CITY OF ALBUQUERQUE

September 6, 2013

**Re: Vista Del Norte Community Park, Preliminary Grading and Drainage Plan
Engineer's Stamp Date –no stamp- (E16D032)**

INLET TABLE					
Inlet	Inlet	Basin	Actual	vail	Capacity**
#	Type		Flow	Had ft	CFS
IN1	1-DBL COA TYPE D*	B2	9.55	0.55	14.92
IN2	1-DBL COA TYPE D*	B3, B4	14.21	0.70	21.42
IN3	1-DBL COA TYPE D*	B1	19.92	1.40	44.42
IN4	GRATED MANHOLE COVER**	B1, B5	14.93	1.40	22.40

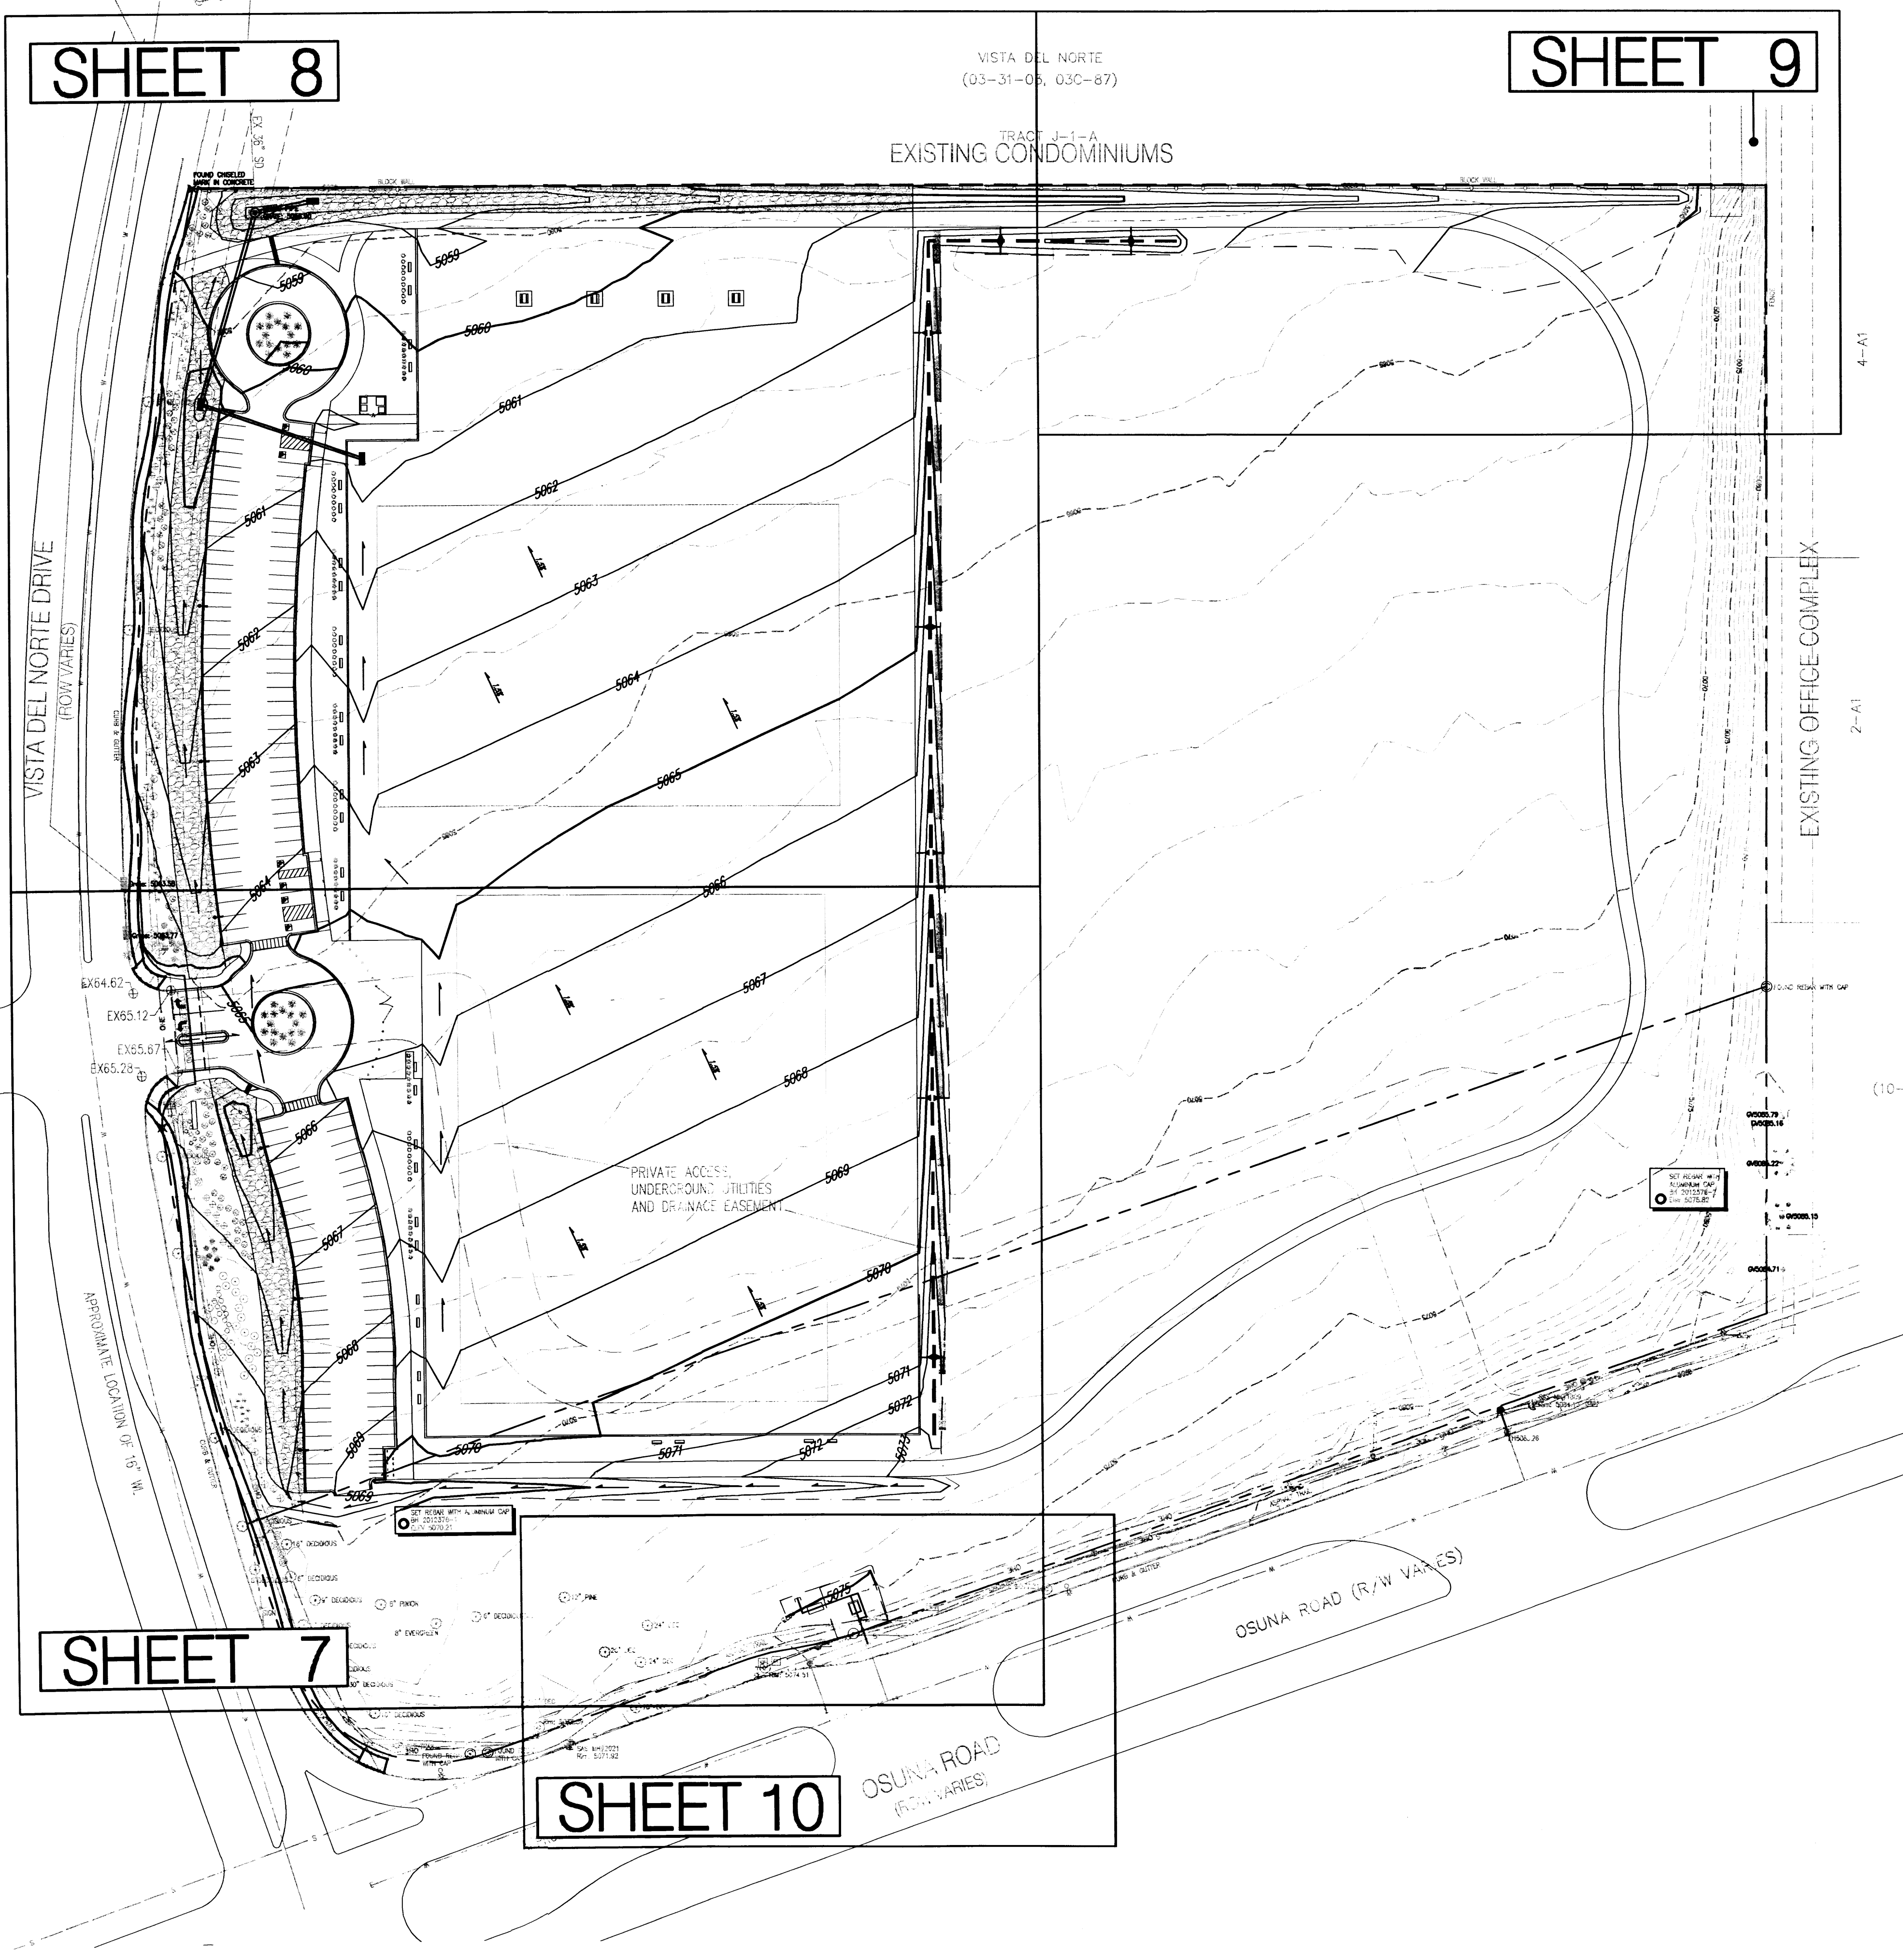
1. It appears the inlets and actual flow data for SD3 and SD4 were transposed in the table.
2. The narrative in the conclusion section mentions the 100 yr-24 hour storm. The 100 yr-6hour storm should be used for design.
3. Is it possible to move the proposed swale in Section B-B, so that 1' or more of "flat" area is proposed between the wall and the edge of the swale?
4. Provide a "blow-up" of the northwest corner of the site where the inlets are located at a 1:20 scale minimum.
5. CPN 6920.81 shows only a stub constructed where the site storm drains tie in. Provide a detail of the box or similar at the confluence of the storm drains as well as the HGL.
6. Provide water block/high point grades at the site entrances.
7. Provide the WSE in the swale in section B-B in appropriate locations.
